OBJECTION TO GLEBE FARM MARINA CLAYDON

Revised Application Ref. No. 20/02446/F

OBJECTION BY ROBERT ADAMS B.Sc. *Landscape Architect (retired)*

AdamCM-1-5-001A (Site Location Plan)

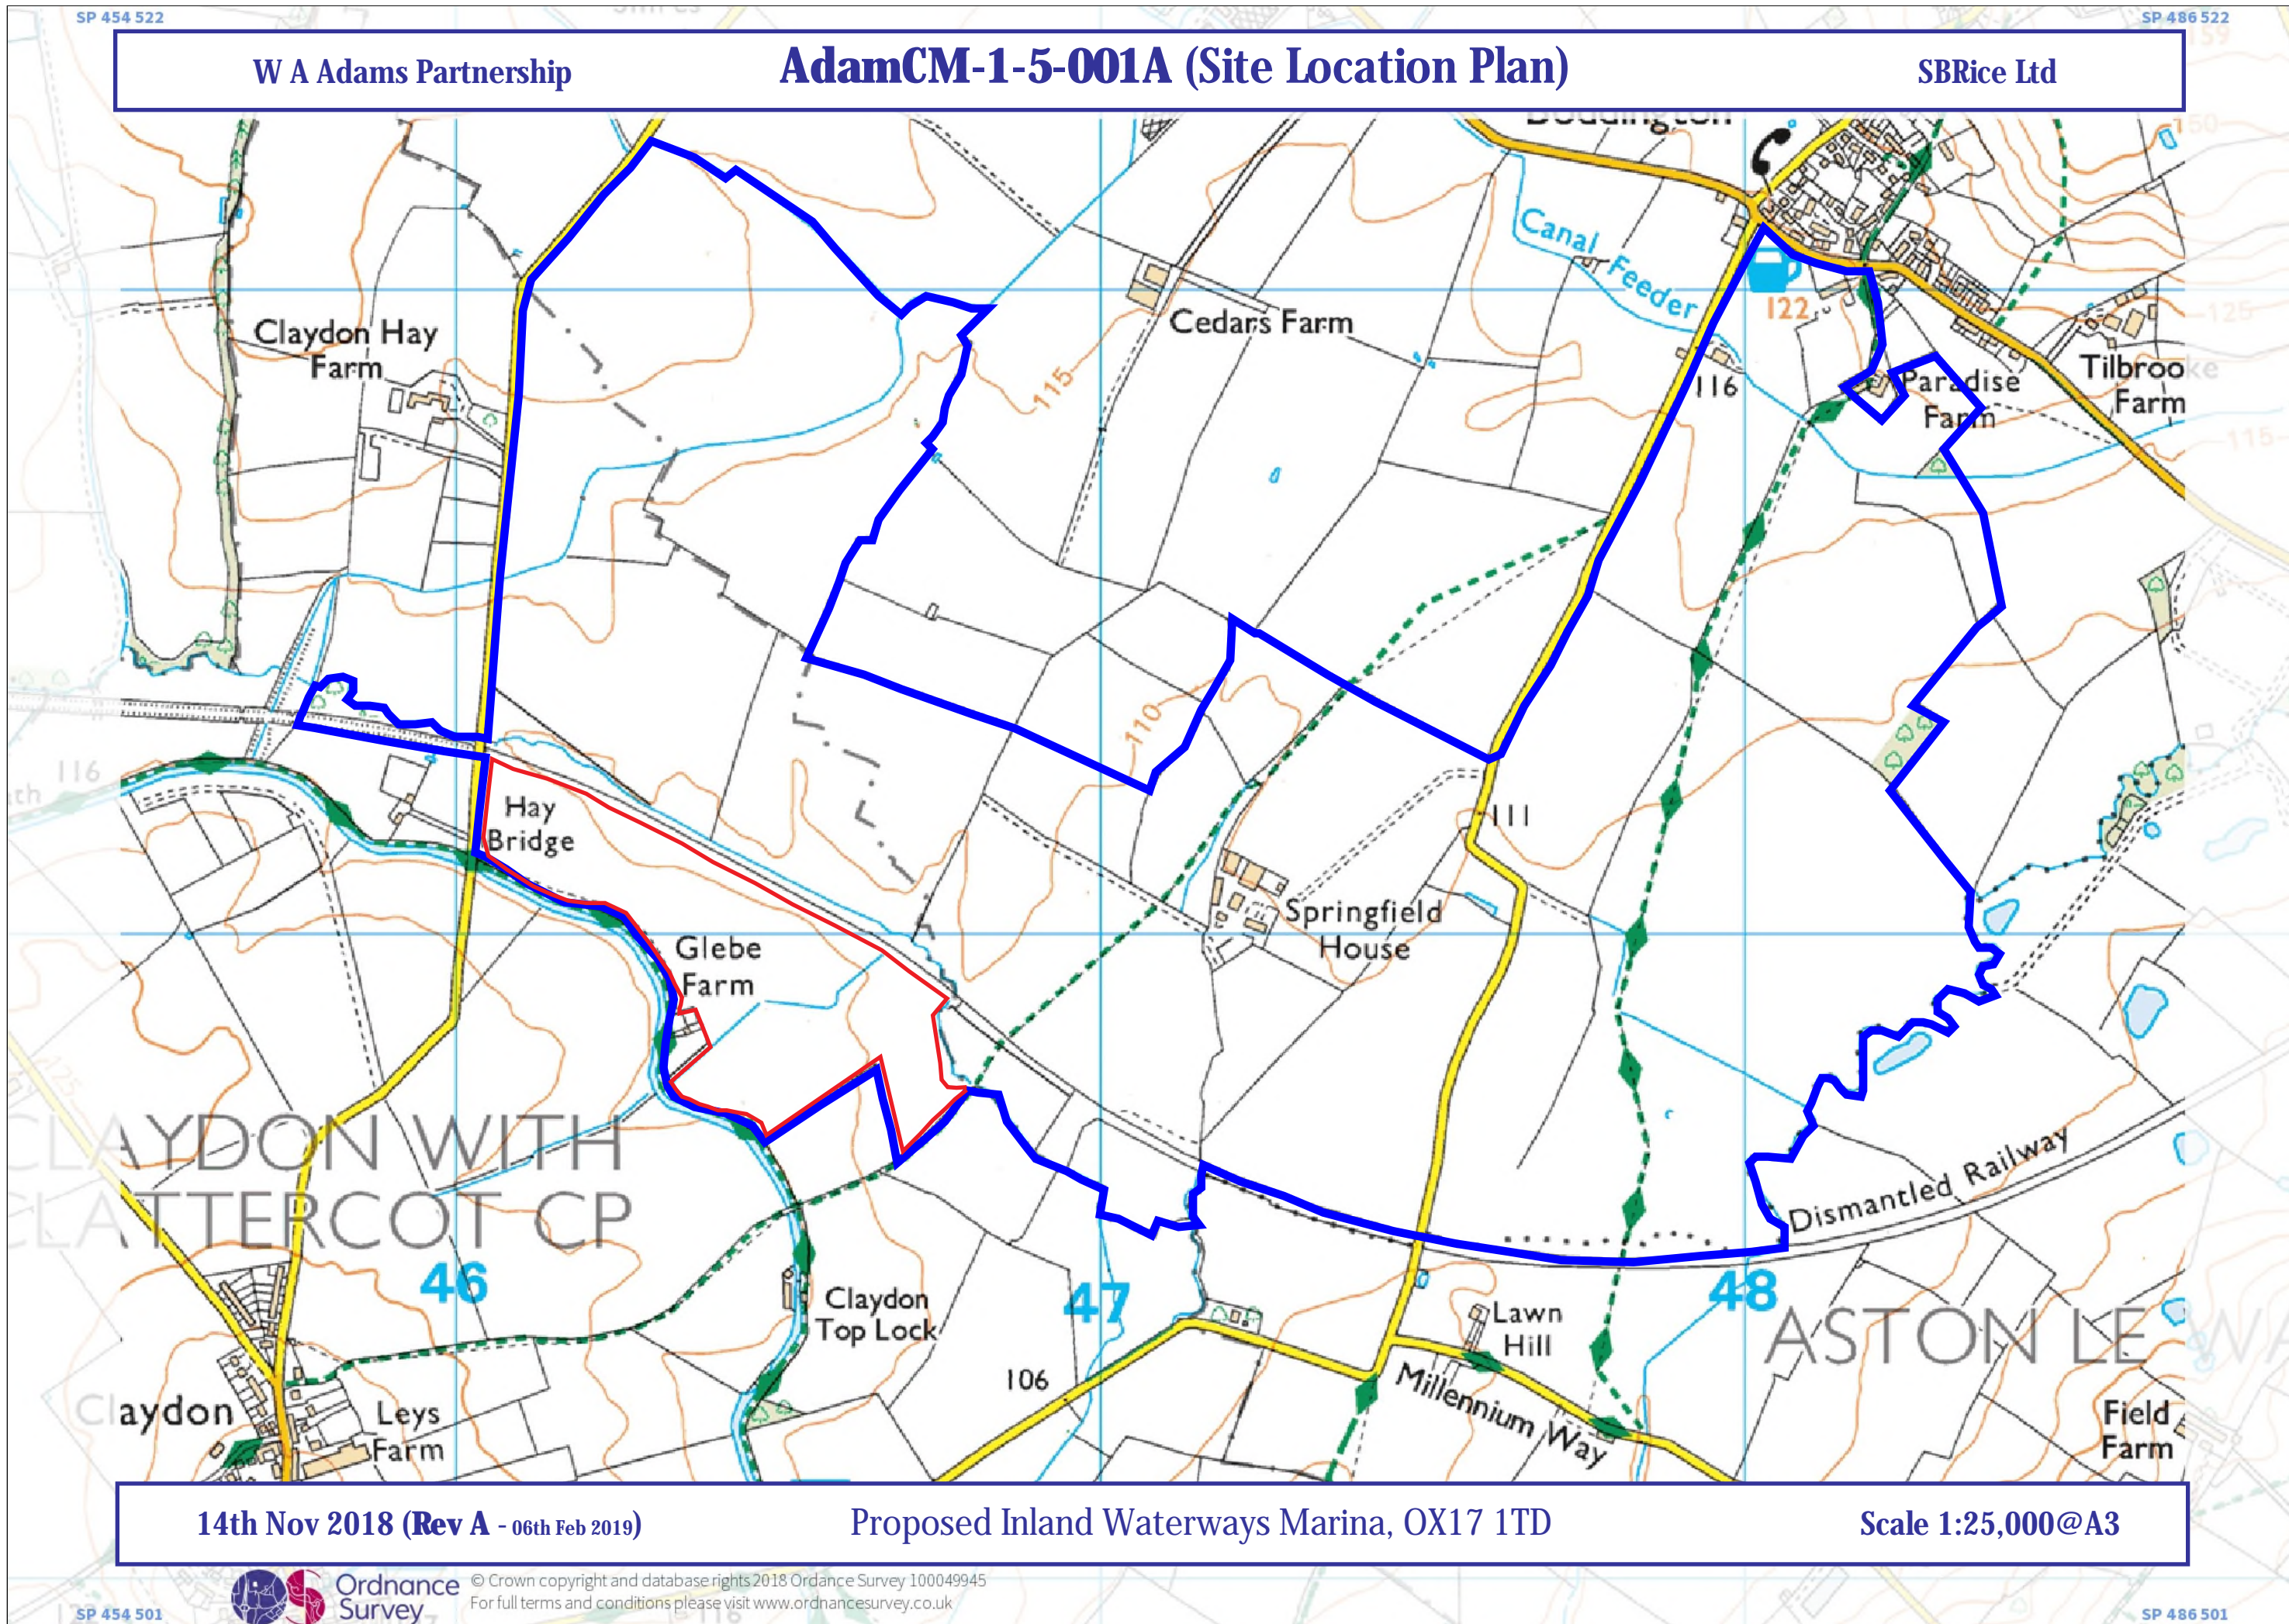
3.1 Levels and contours are expressed in a different way on different maps and this leads to confusion when trying to assess how they work. Drawing ADAMCM-1-1-001 is incorrectly dates 2017 as title block includes survey date of Nov. 2019!

CAD File Name  
 L:\Banbury Marina\A05-601B\_Bridge details

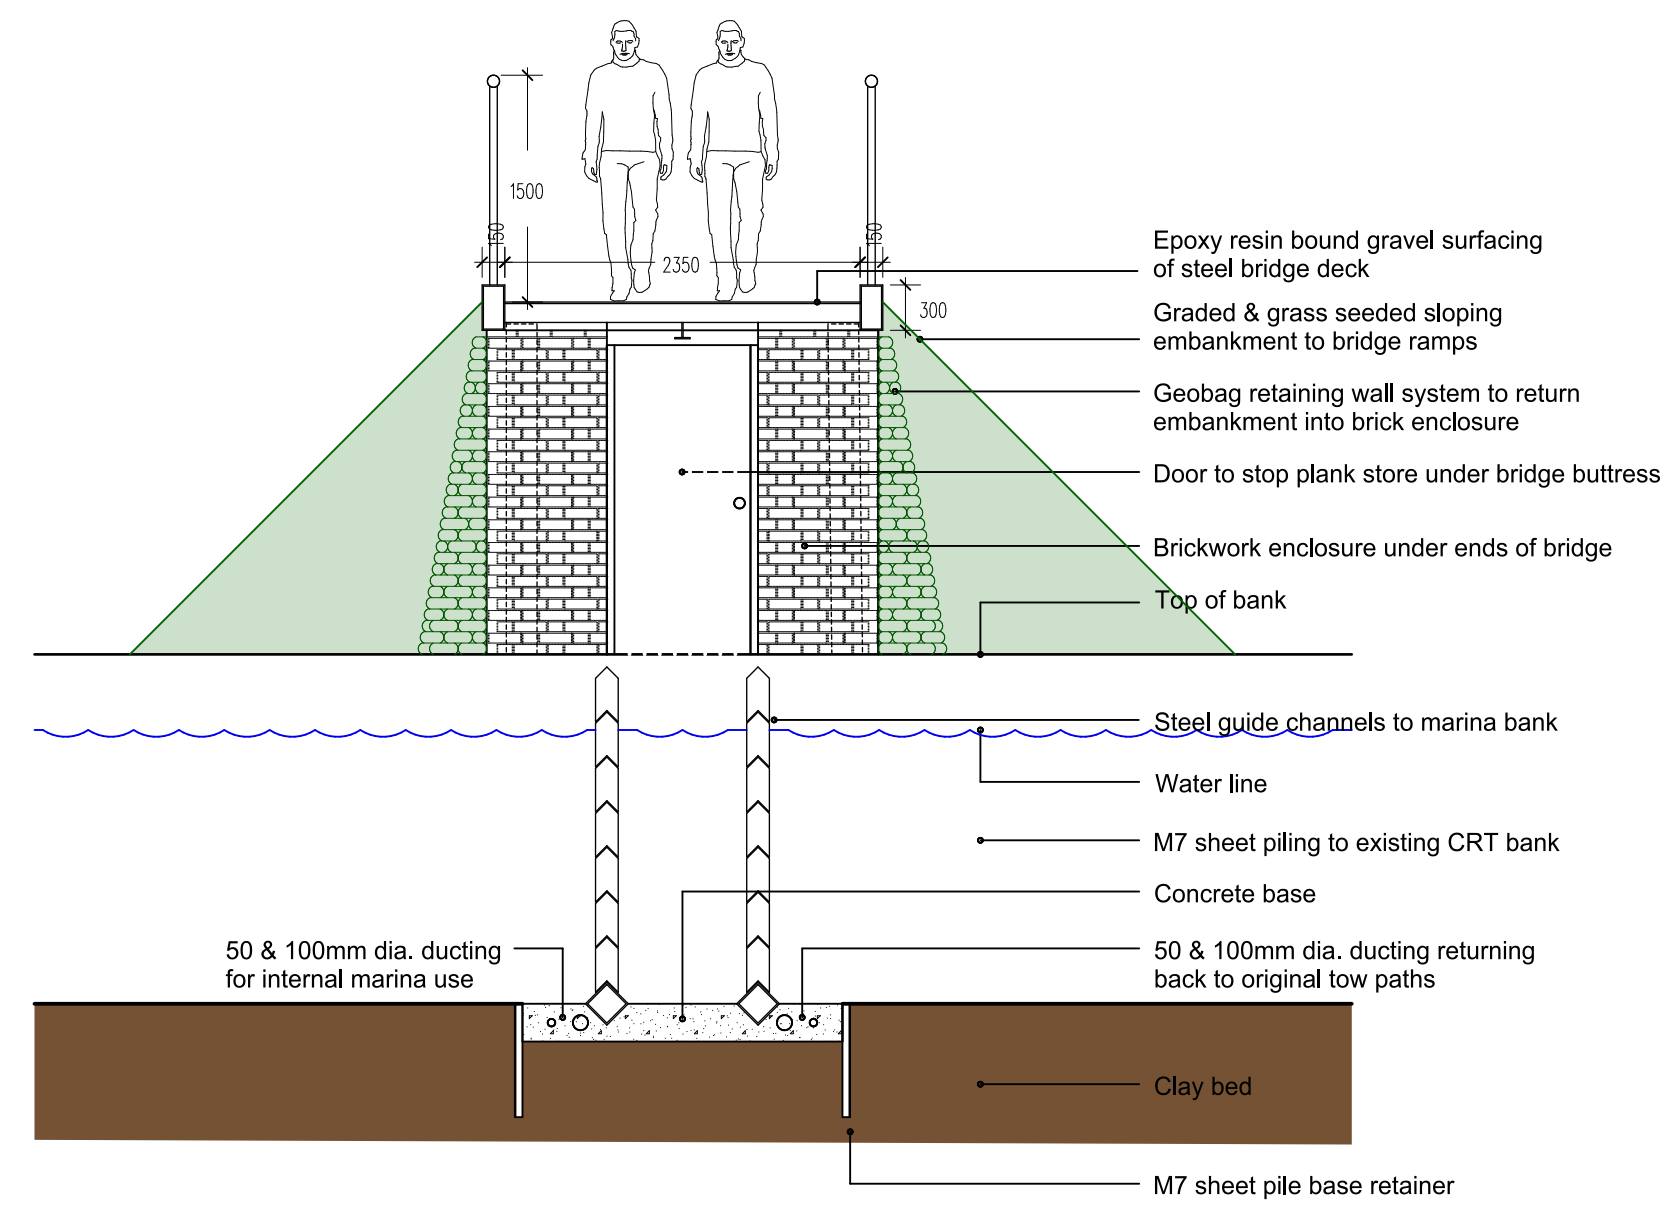
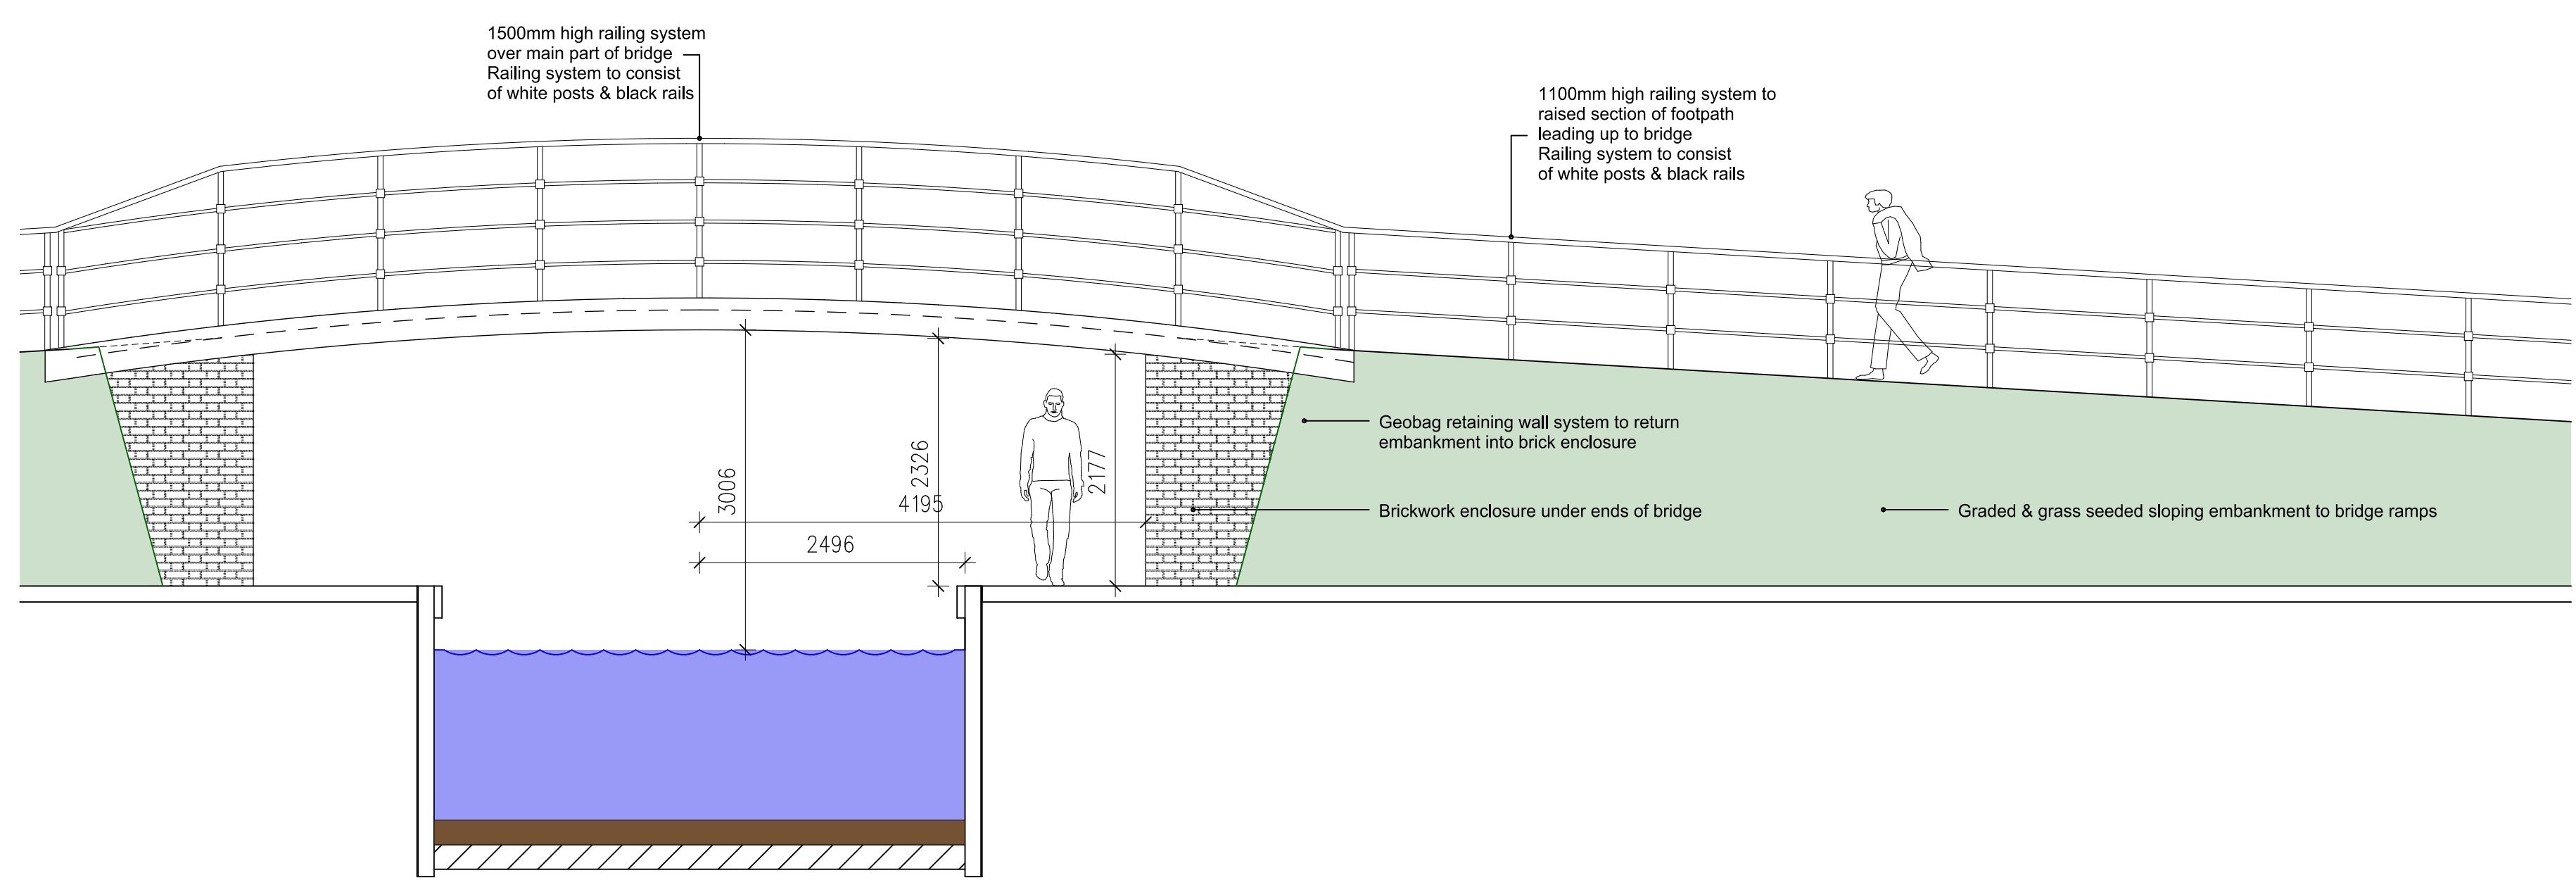
2.2 The drawing of the Towpath Bridge – A05/601B 25/10/2018 – It does not show it in its context. There are no details of the landscape adjacent to the bridge, to enable an appreciation of its effect on its surroundings. It will rise to cross over the proposed marina entrance at a height of approximately 117.767 to which should be added the approximate height of pedestrians on the bridge, i.e. eye level will be at approximately 119.50m. This is 4 m above canal water level and will have no vegetation to screen it in views along the road, from both north and south. Mitigation from the north will not be possible as this land is not in the applicant's ownership, and from the south the planting on the proposed mound will have to reach at least 2 m. height before mitigation occurs. From the bridge over the canal the towpath bridge will be a major structure which in combination with the close by towpath bridge, will be a major intrusion into the landscape. Its colour is not specified. If white, which is so frequently used near water, this would make it appear even more visible from the Lower Boddington road.

PROPOSED EASTERN DETENTION BASIN TYPICAL SECTION
Scale 1:100

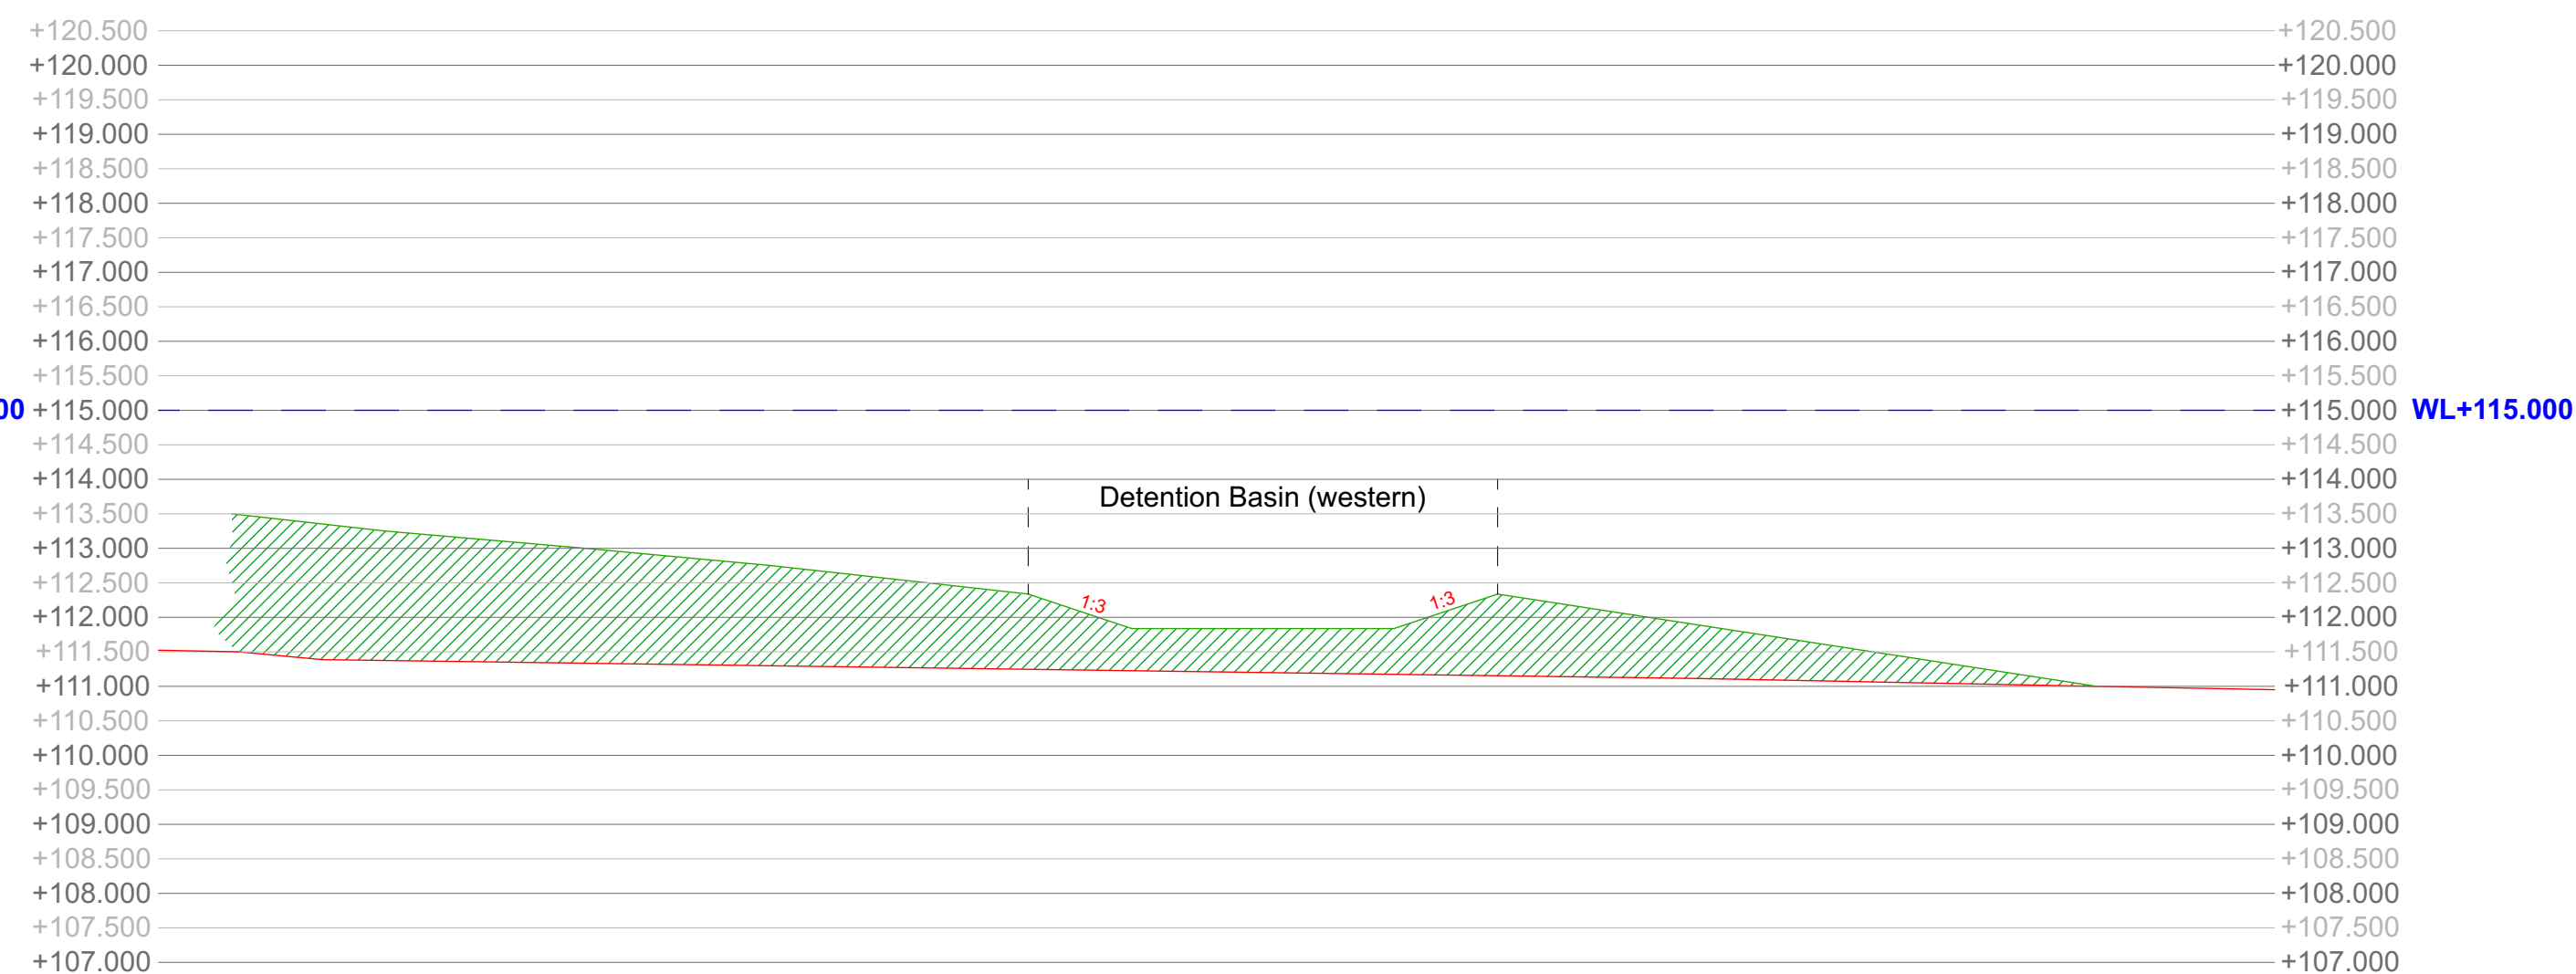
the mounds created by the Lower Boddington Road and their obliteration of views over open countryside and their relation to the levels of the Lower Boddington Road and canal bridge. The levels on the road is 114.00 while on the detention basin drawing it is shown as 110.50, and its relationship with other site levels is not established. The relevant drawing is ADAMCM-1-4-003 dated 21/08/2019 where the adjacent earthworks to the south are not shown, which would help people's appreciation of the great height of the proposed earthworks.
